Pod B, P5 Car Park, Sydney Olympic Park – Agreement for Lease – Draft Development Application

I refer to the draft Development Application submitted by Urbn Surf (Sydney) Pty Ltd to Sydney Olympic Park Authority (SOPA) on 12 April 2017, as required under Clause 7.2 of the Agreement for Lease.

SOPA has reviewed the documentation and suggest the following amendments to your draft Development Application.

Figure 5: Groundwater levels and direction of flow

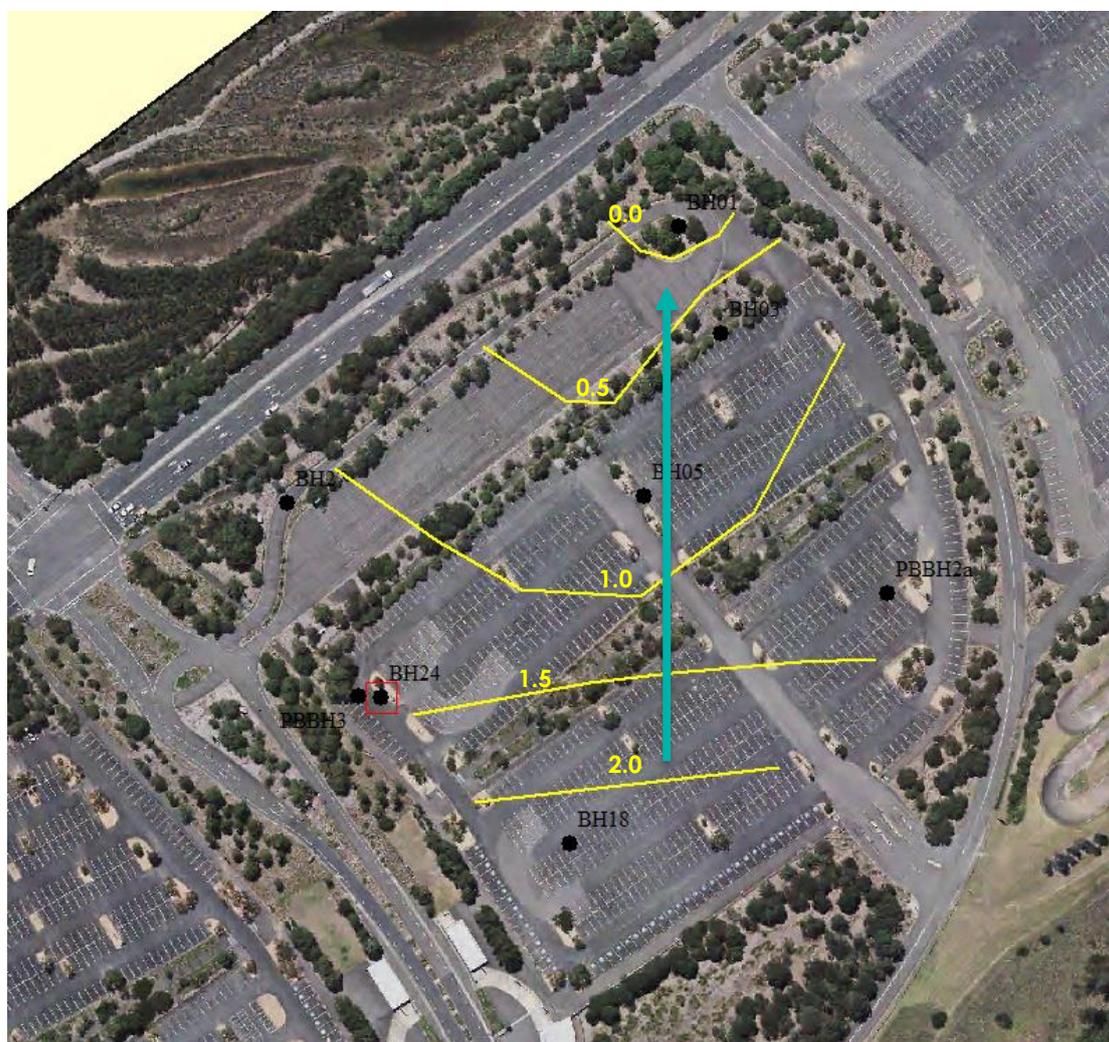
3. Topography and Geology - Reference provided is inadequate and site specific hydro-geological verification and assessment is required with respect to:

- Saline soils
 - Acid sulphate soils
 - Ground water hydrology and hydrodynamics
4. Water discharge - Include typical characteristics of quality, chemicals and residual generated on site (volumes, concentration, i.e. backwash water from pool filters and details of on site treatment or disposal method. Provide details of trade waste, liquid, grease etc. that would be generated on site and how these waste would to be managed

Figure 12: Proposed circumstantial discharge route

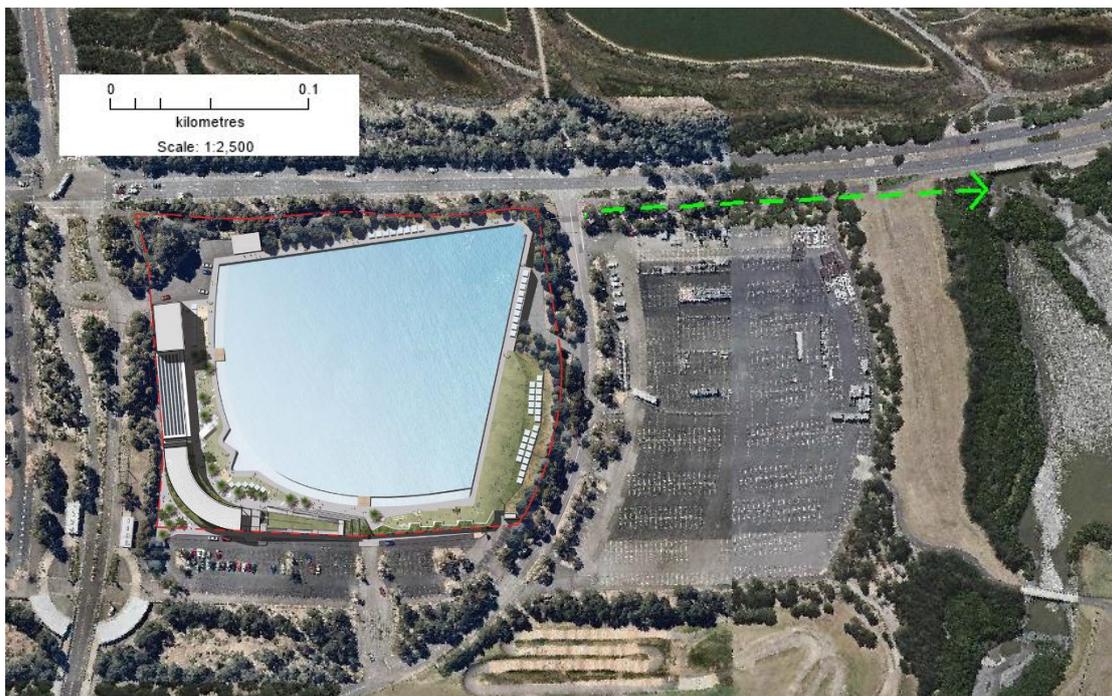
2. Lagoon Water Discharge - Provide details of the subsoil drainage system beneath the lagoon, control and management, including water quality any water treatment if required

Figure 14: Intensity frequency duration chart and statistics for the site (Source BoM, 2017)

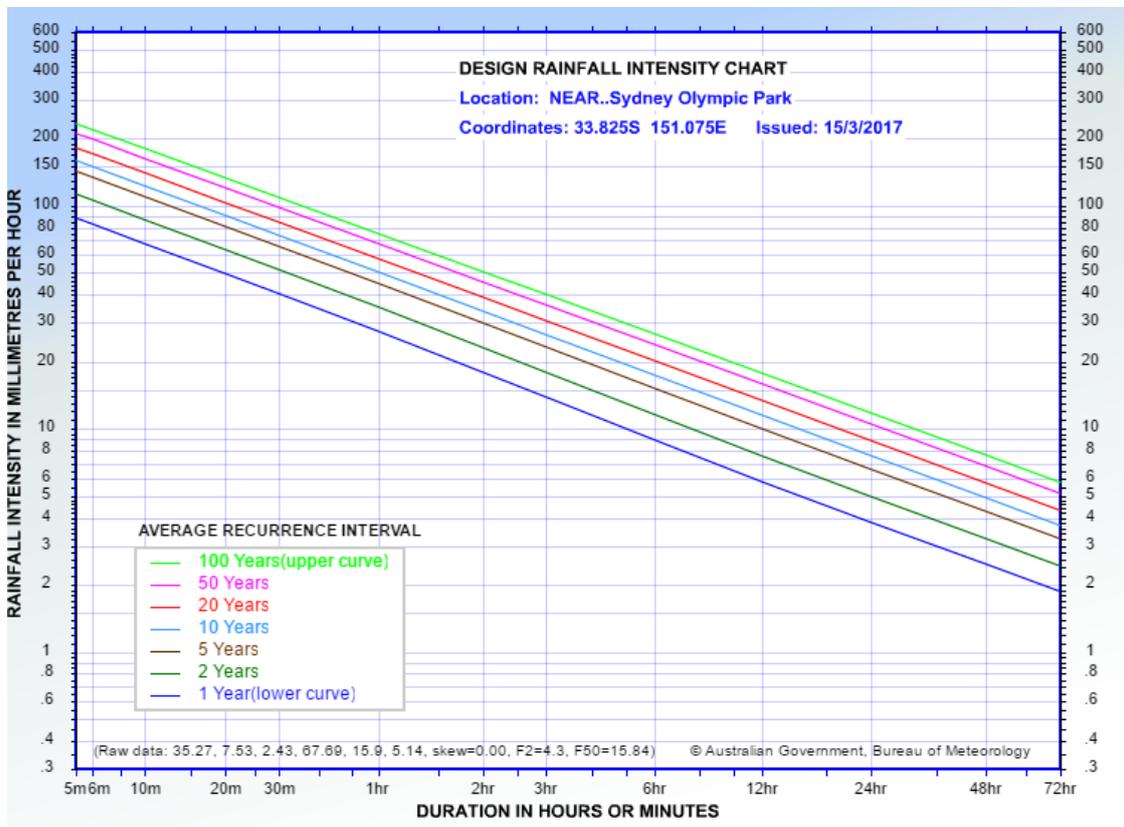
6. Hydrology – Provide reference to data sources used in calculation and methodology i.e. ARR
 - o Flood risk – Include information and evidence that flood levels estimates include:
